From: Michael Eastham
Sent: 01 March 2018 11:38
To: Planning.Responses
Subject: FW: BN/52/16/RES - Amended plans for the former Pollards Nursery site, Lake Lane, Barnham

From: Mark Warwick
Sent: 01 March 2018 11:05
To: Michael Eastham
Cc: Richard Martin
Subject: RE: BN/52/16/RES - Amended plans for the former Pollards Nursery site, Lake Lane, Barnham

I have reviewed the *Substitute planting plan 2600 pp-12 Rev P10 14/02/18* which relates to compensatory tree planting following the planned removal of Leyland cypress trees alongside 49 Nightingale Lane and to the North of same.

APAL FILE REFERENCE
2600-PP-12-13.dwg

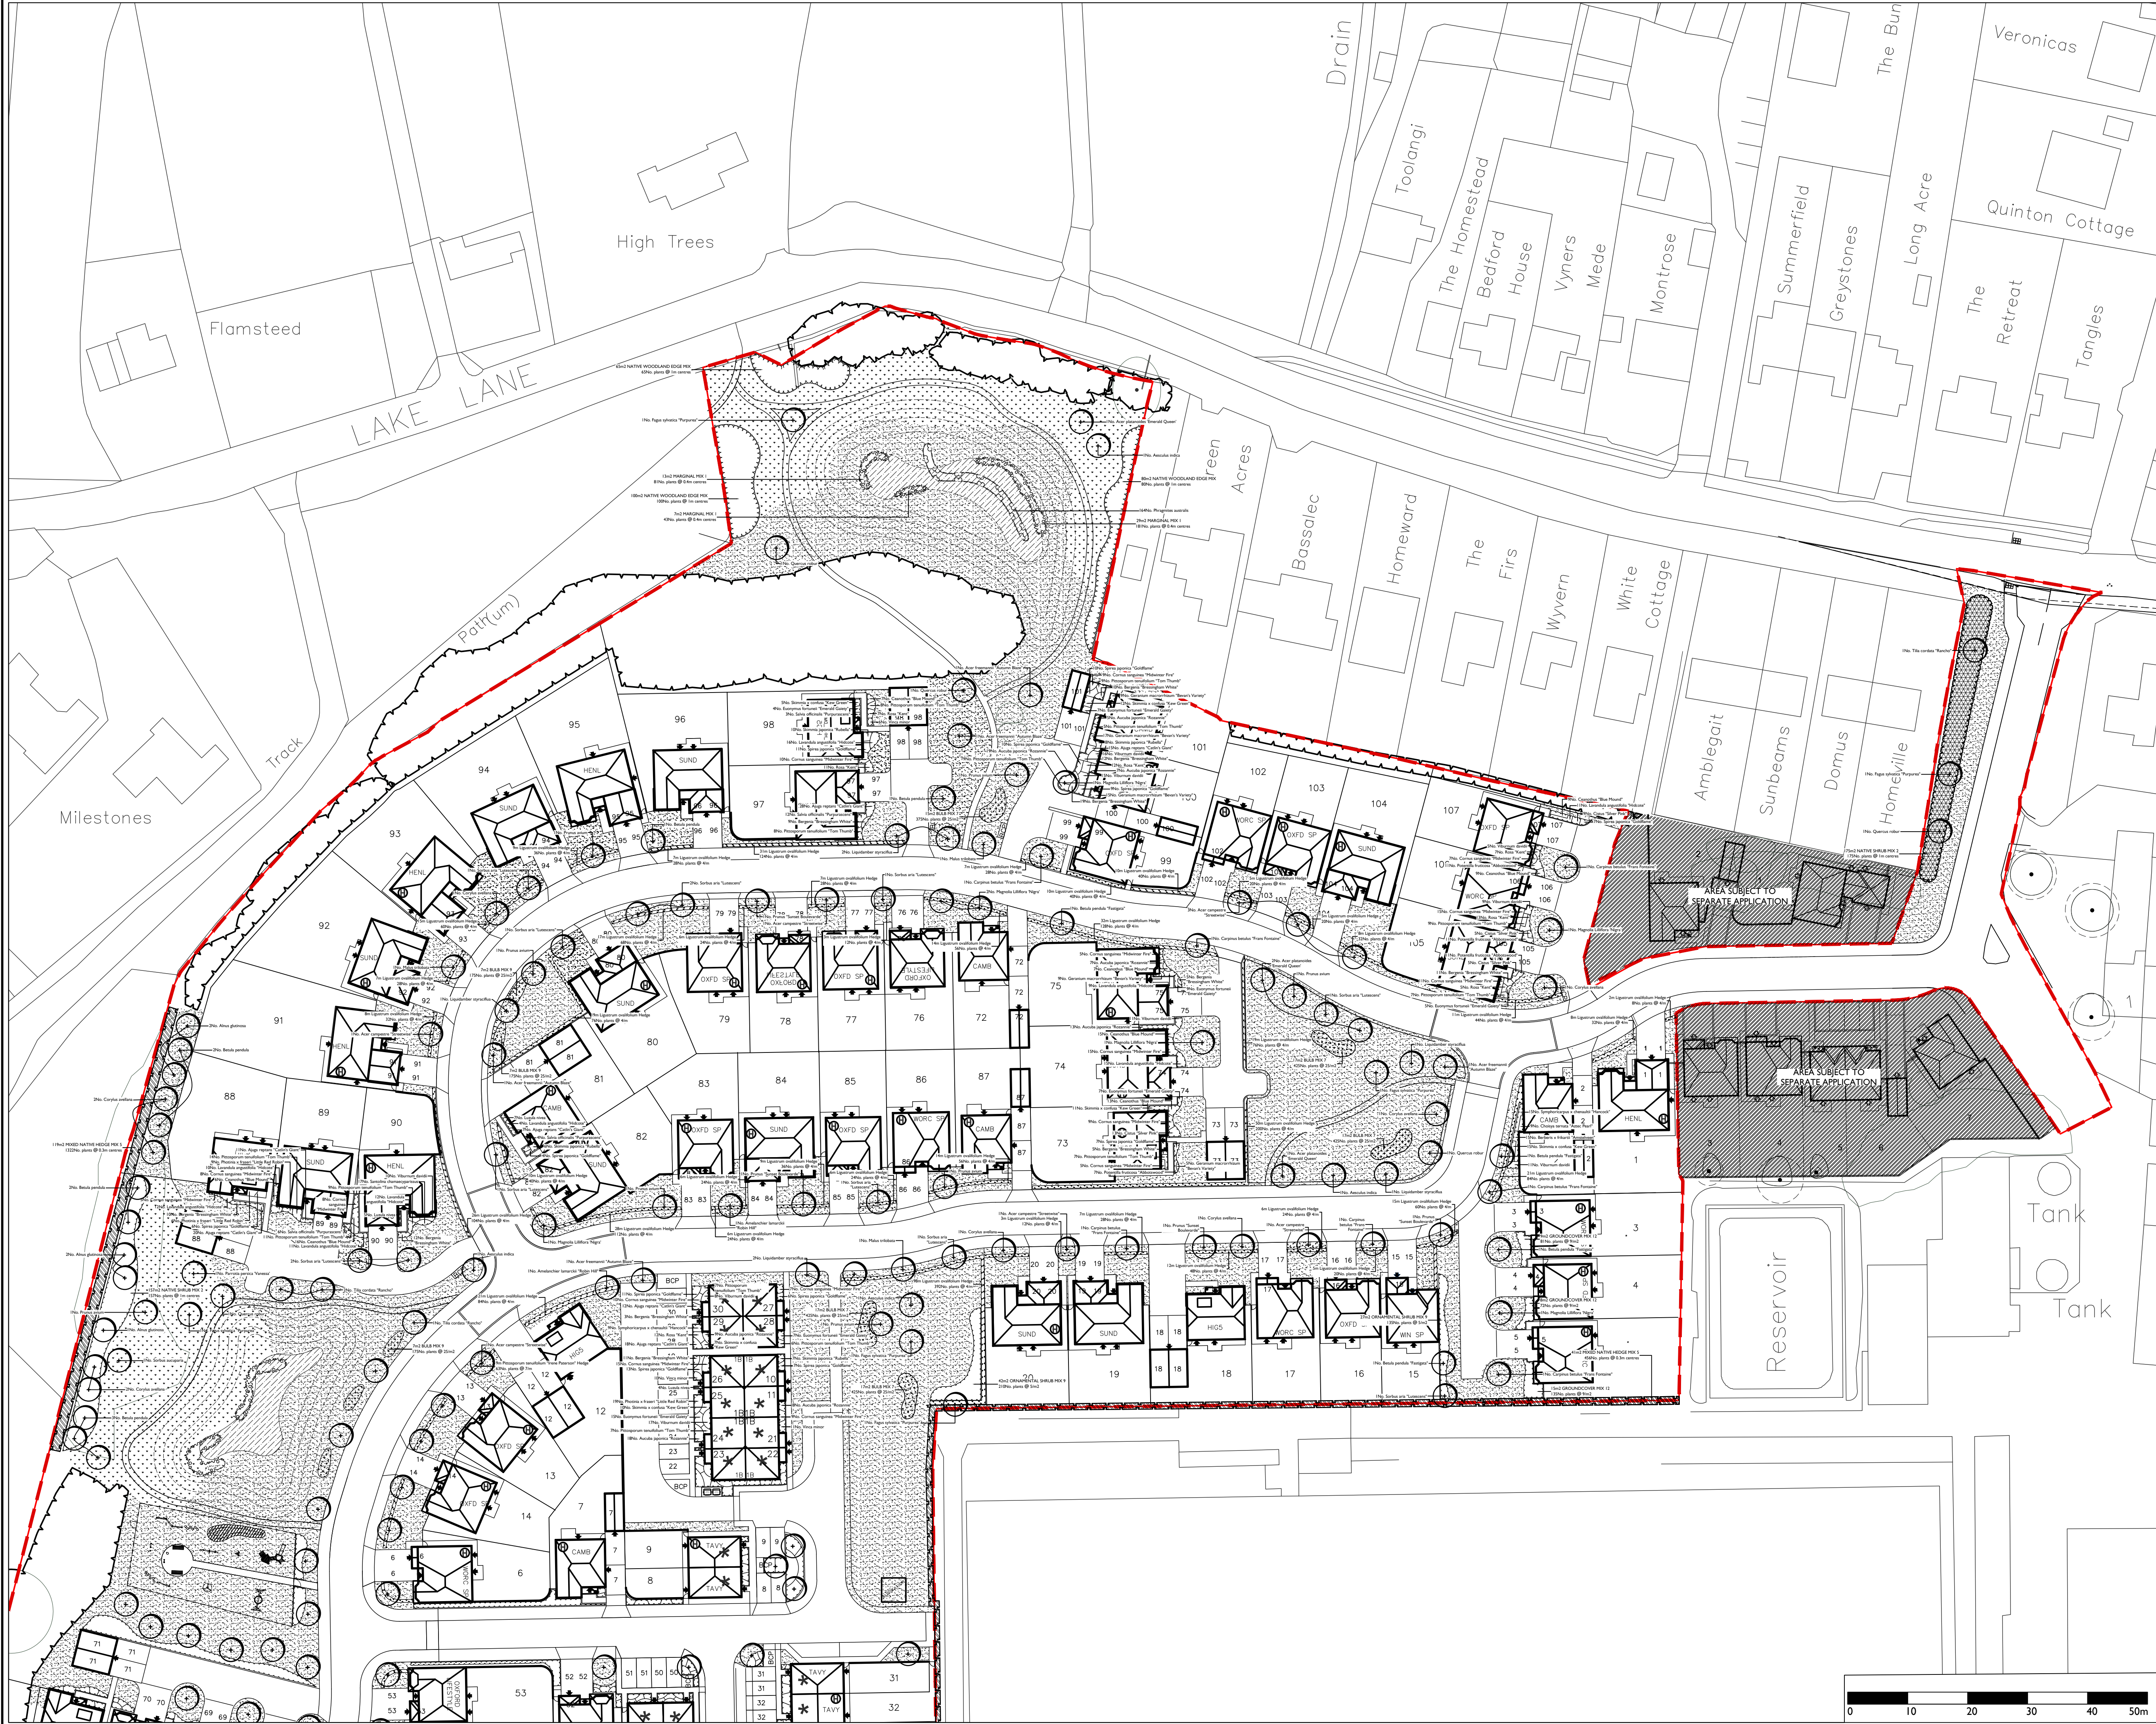
This accords with our earlier agreement with the developer's appointed arboriculturist (RPS) *Arboricultural site inspection 01/02/18* and so we can support the scheme as presented.

There are no outstanding arboricultural issues arising from this additional plan.
